Reference: 15S1505000

17 March 2016

2 FIGTREE DRIVE, SYDNEY OLYMPIC PARK - RESPONSE TO TfNSW COMMENTS

I am writing with reference to DPE letter dated 15 December 2015 and TfNSW letter dated 13 November 2015. I have reviewed their comments and responded to each of them in turn below.

B99 CARS LEAVING VISITOR AND RETAIL CAR PARK

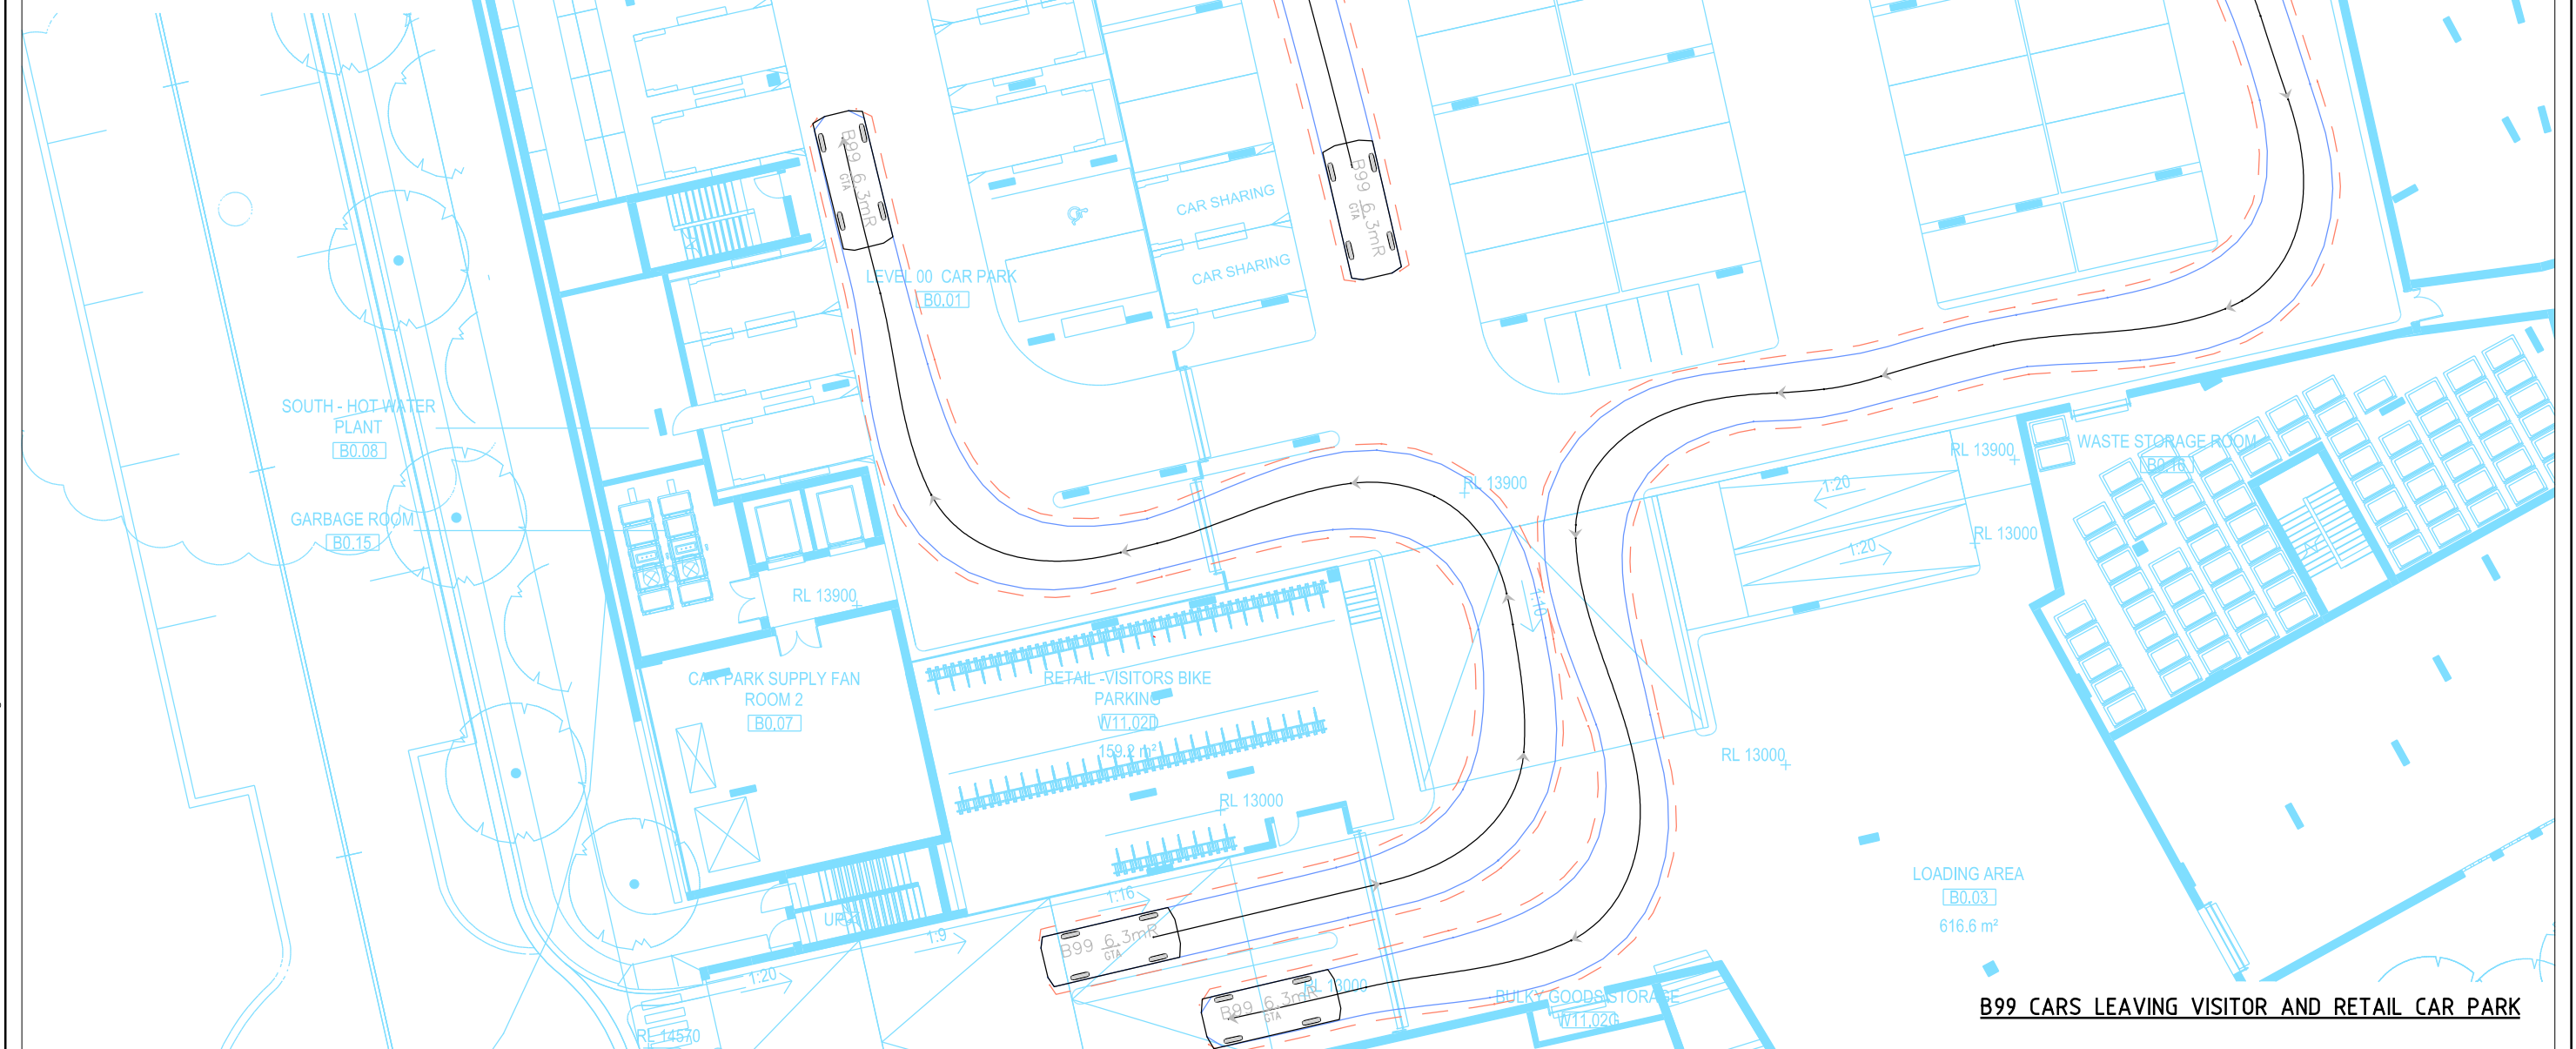
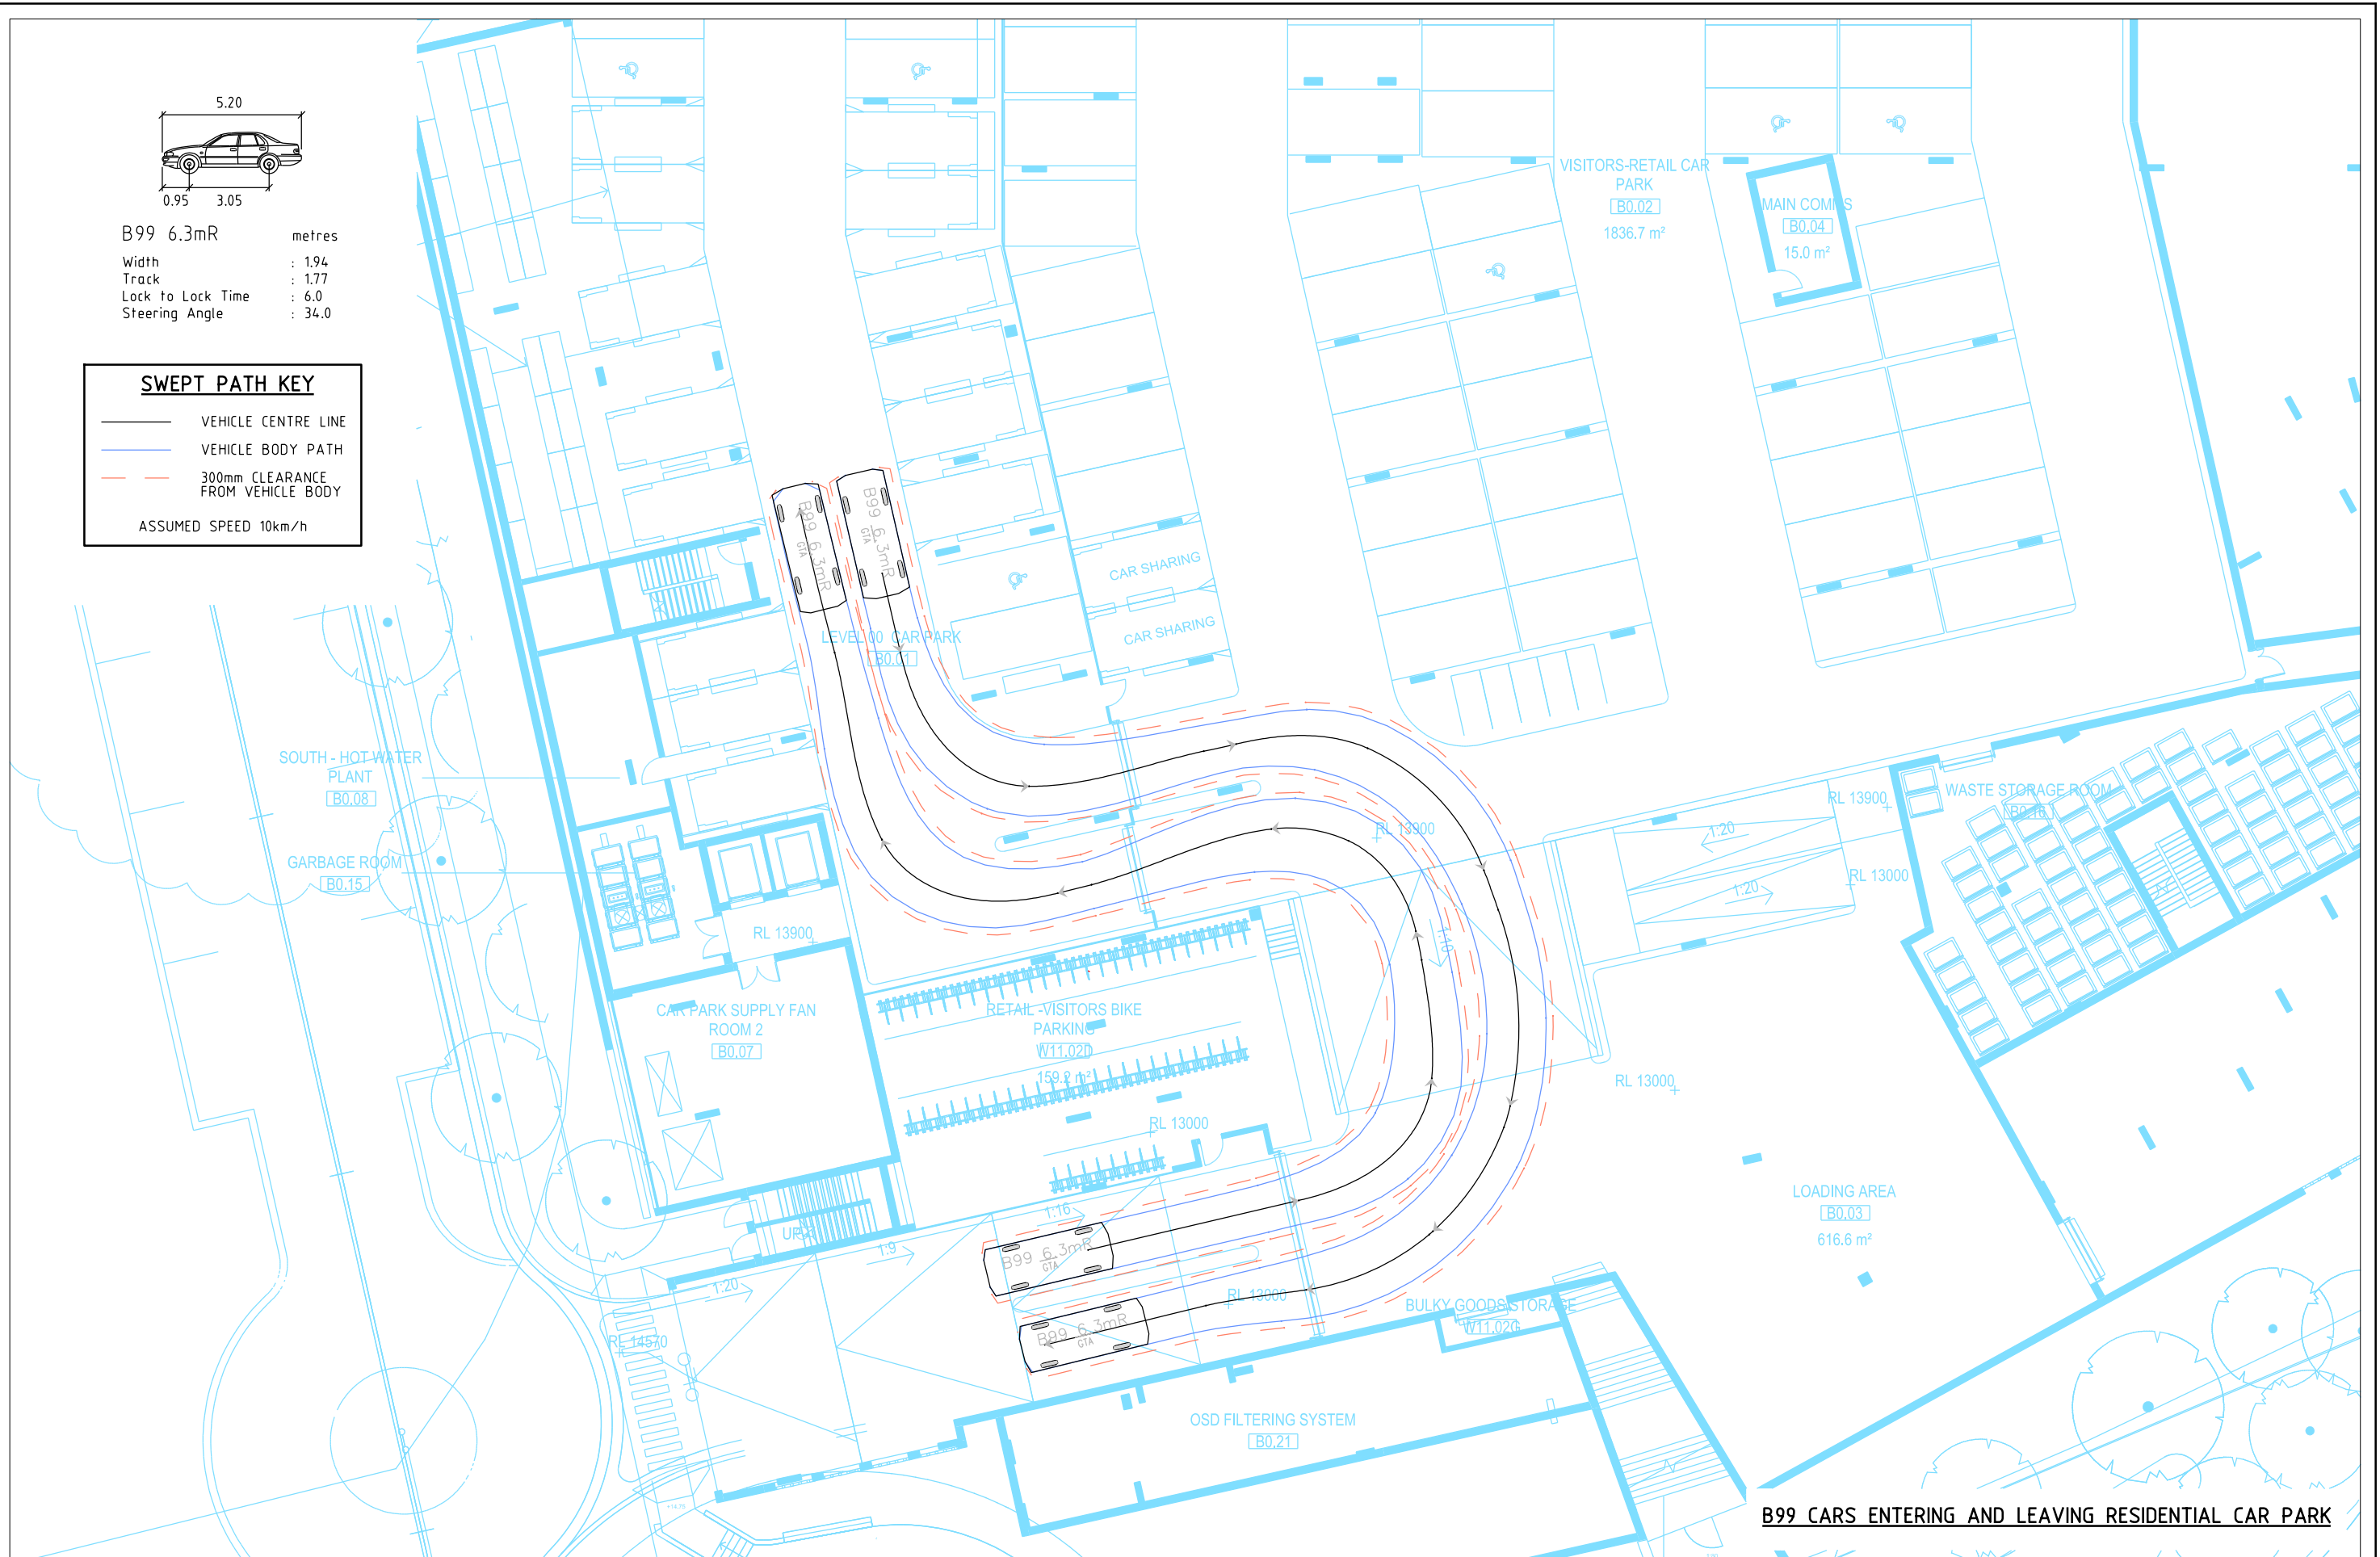
However TfNSW also raises the issue about "potential congestion within the basement carpark resulting from the proposed access ramp between split levels on each level".

Each car park level will contain on average of approximately 180 car parking spaces (the ground floor car park would have less parking spaces as it has a smaller footprint) and cars will all leave the site via a single access ramp. The conservatively estimated traffic

generation of the site will be a total of 111 vph during the busiest peak period. This equates to two vehicles per minute. With regard to the entry controls to the car park it is also noted that AS2890.1 Appendix D points out that lane capacities at exit/entry ramps are in the order of 600 vehicles per lane when in free flow and this is still 300 vehicles per lane per hour at a boom gate. It is clear from the proposed levels of traffic that this would not result in "congestion" in the car park.
